New single storey rear conservatory extension & new front porch
29 Wendy Ridge Rustington

I regret that I am unable to accept your documents as a formal application until the following matters have been resolved :-

Drawing Number	Rev
TRG/110221/01	P1

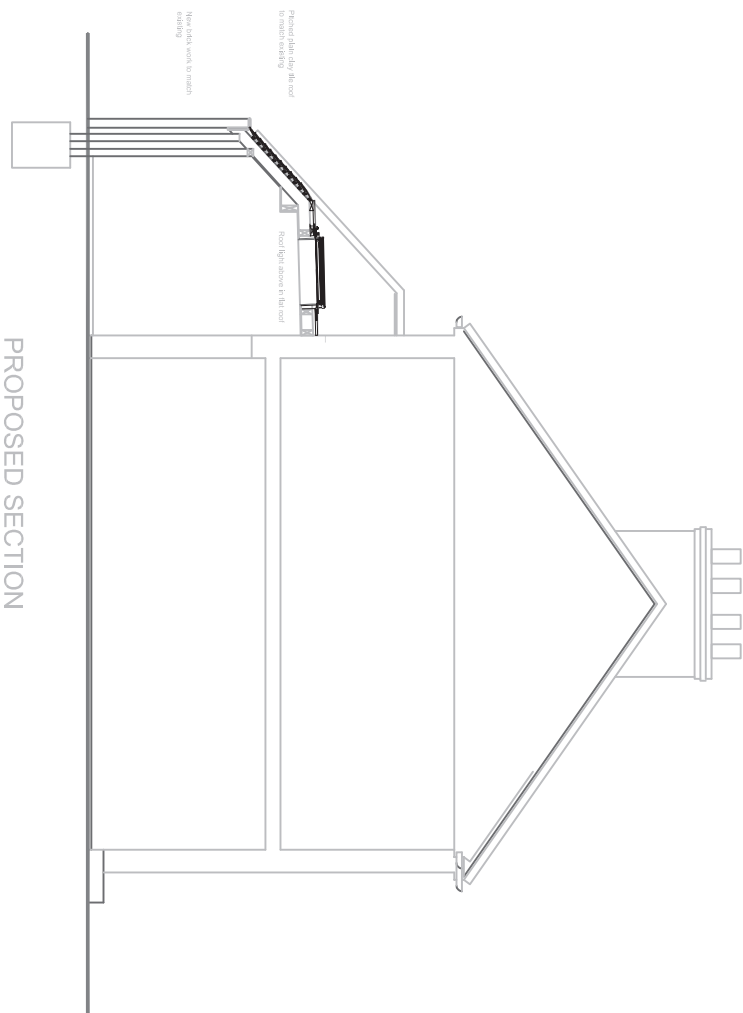
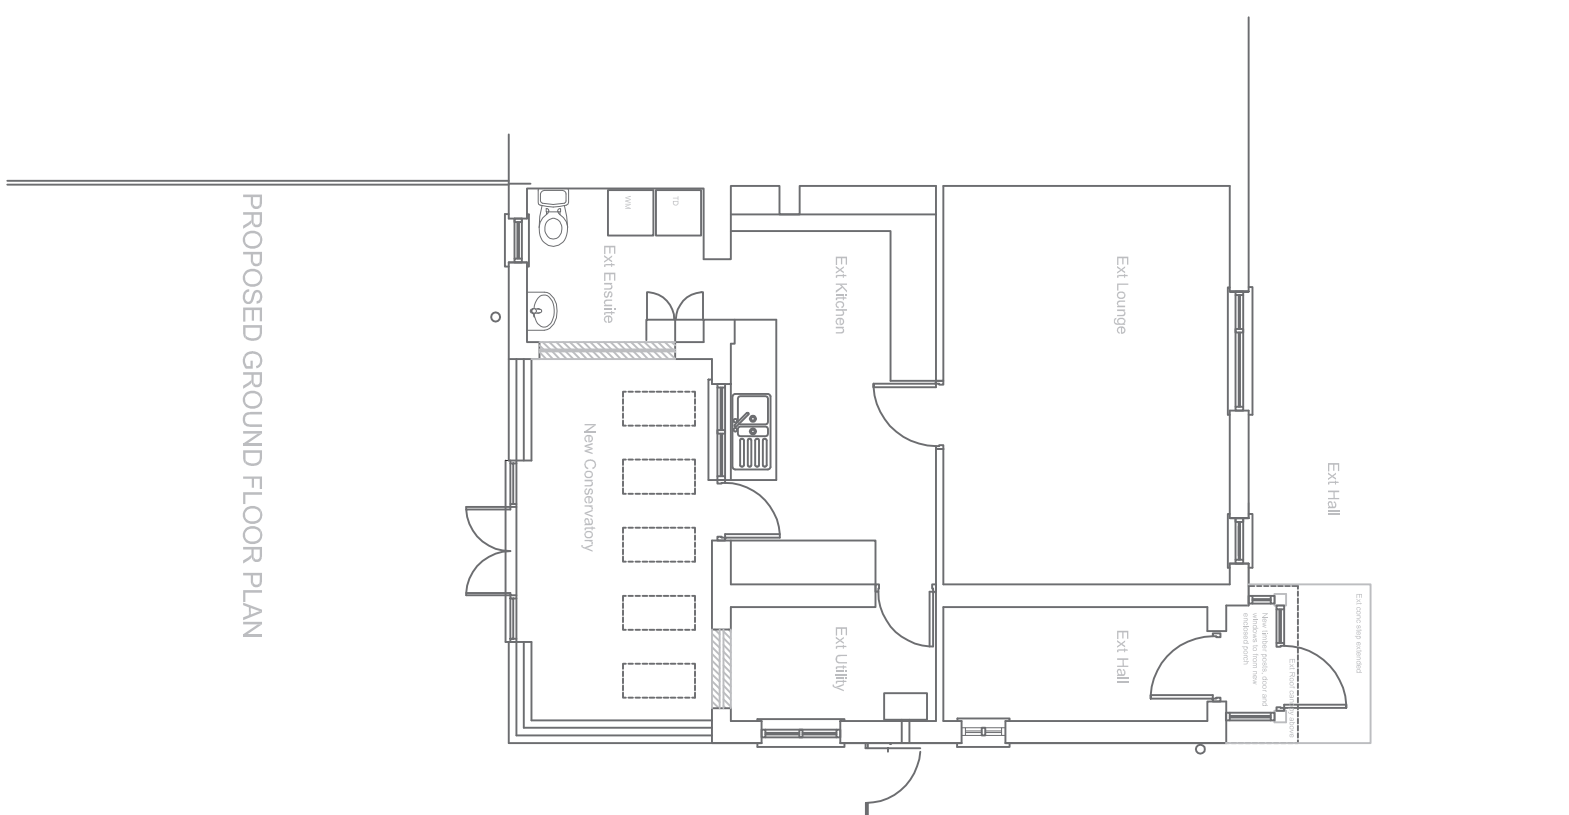
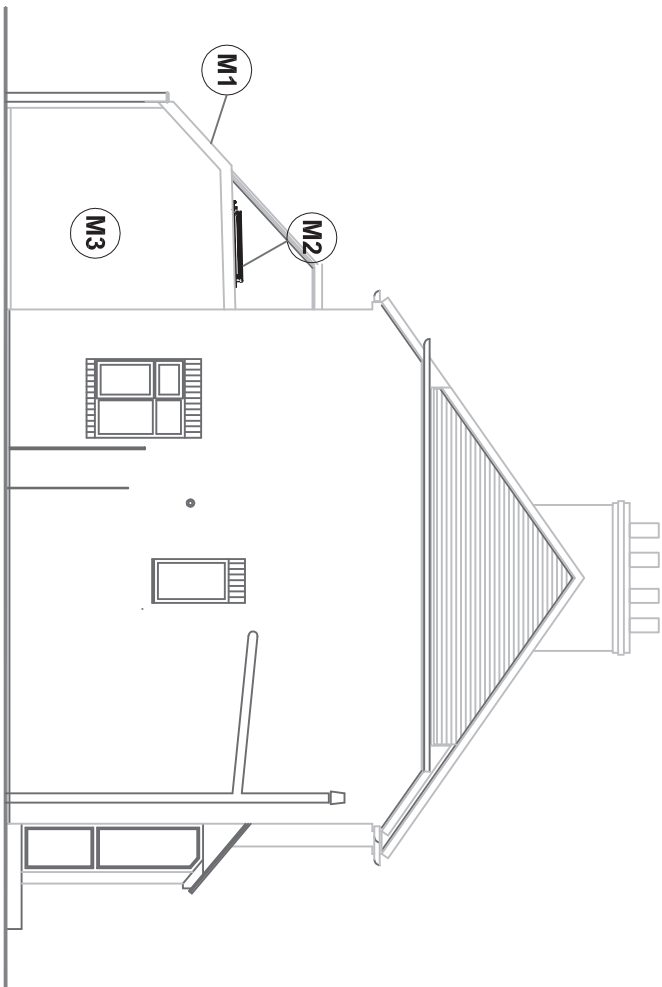
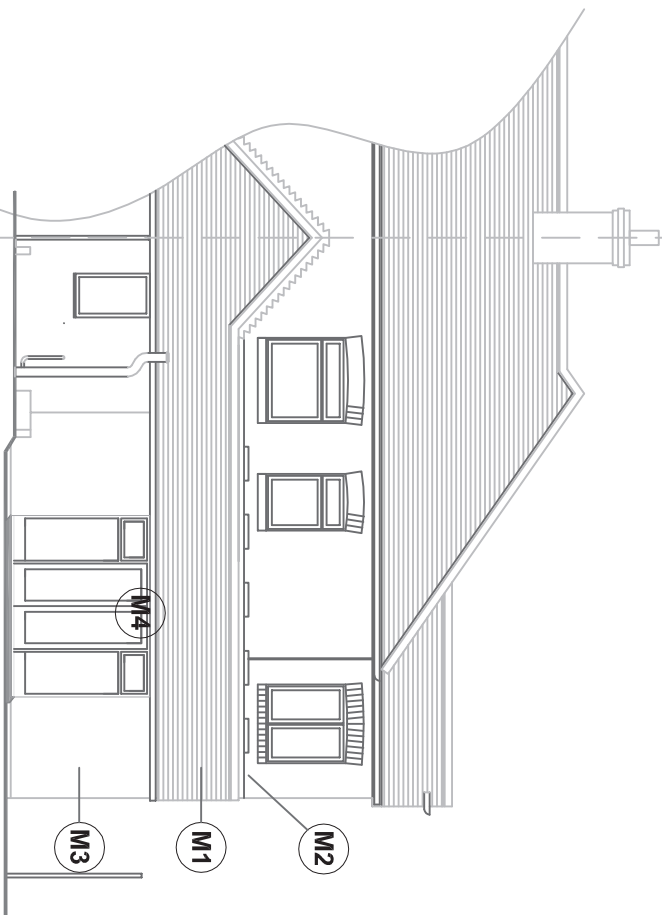
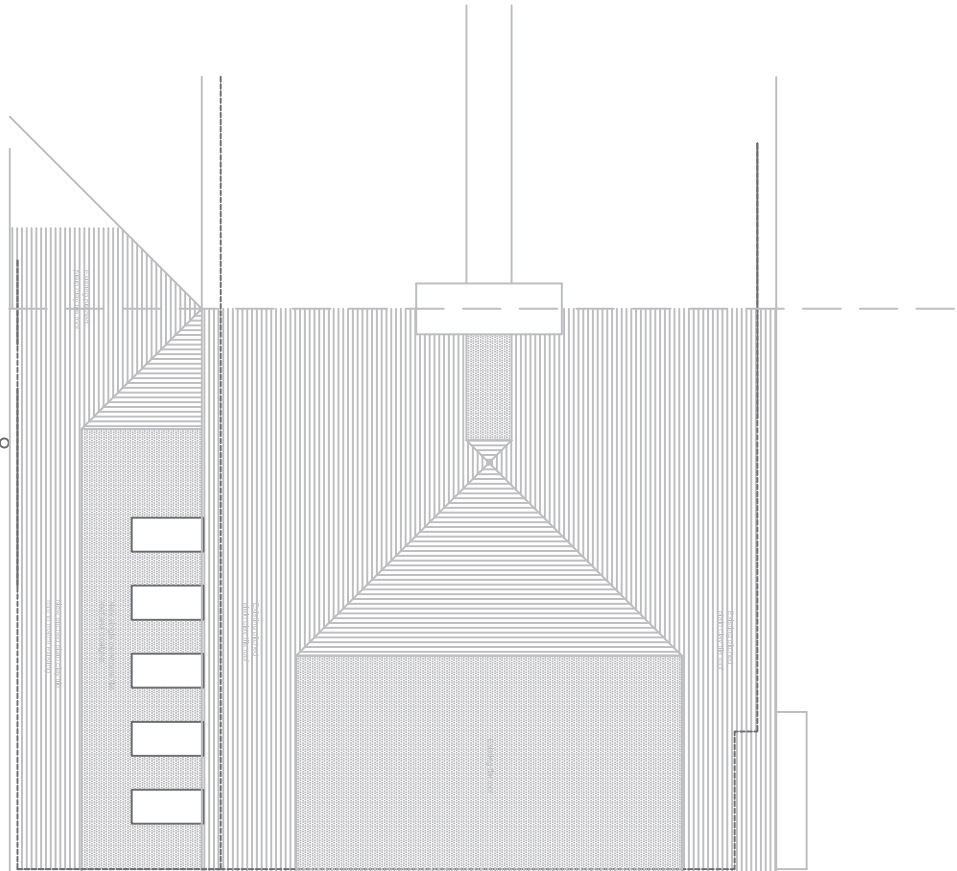
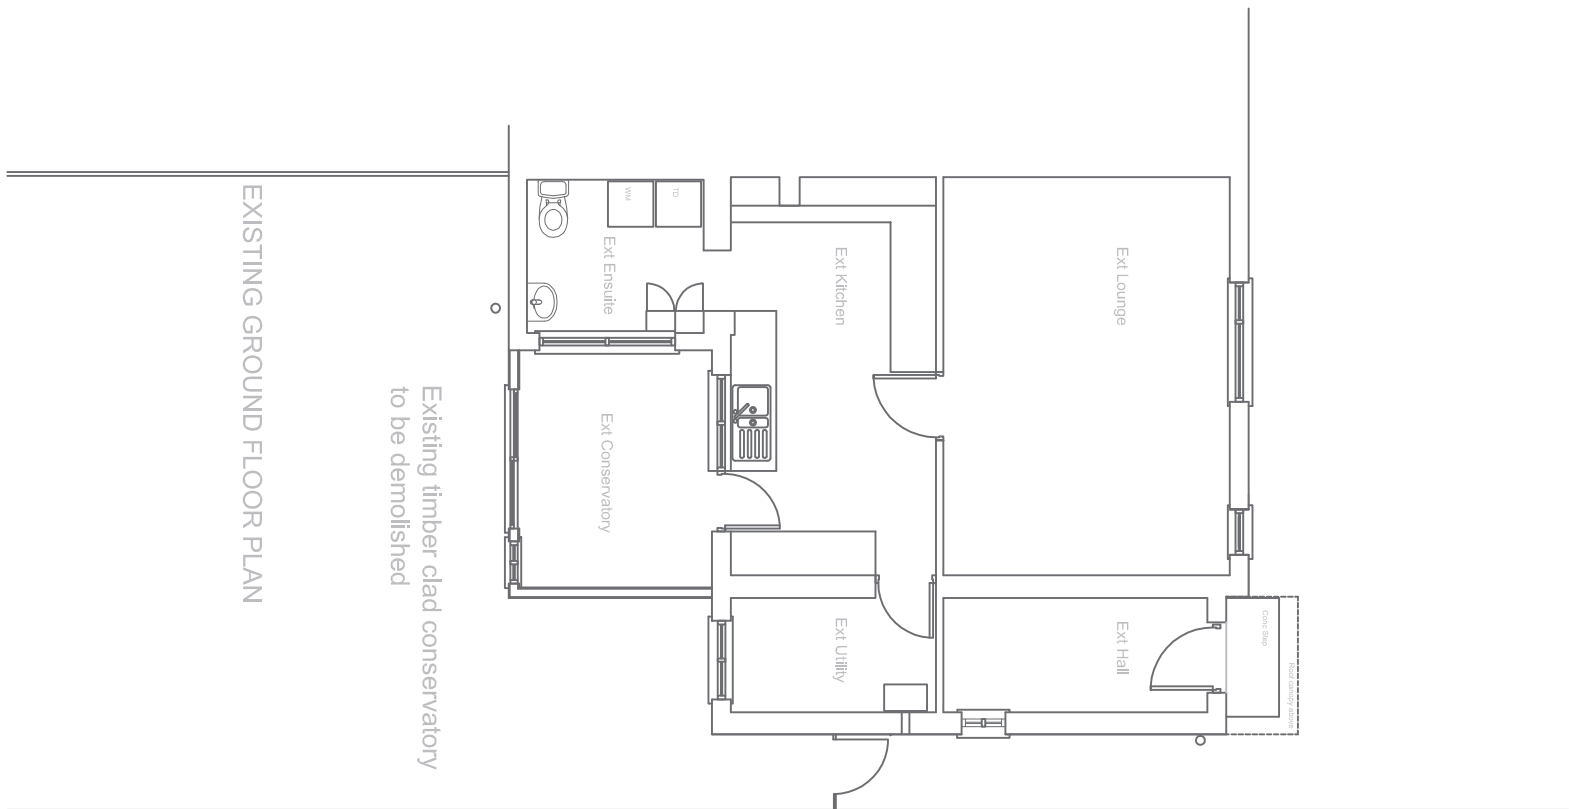
The porch shown on the existing floor plan does not appear to match the porch shown on the existing front (north) elevation. Please amend accordingly.

There appears to be 5 rooflights shown on the proposed floor plan (rear). These will need to be detailed on the proposed rear (south) elevation. Please amend.
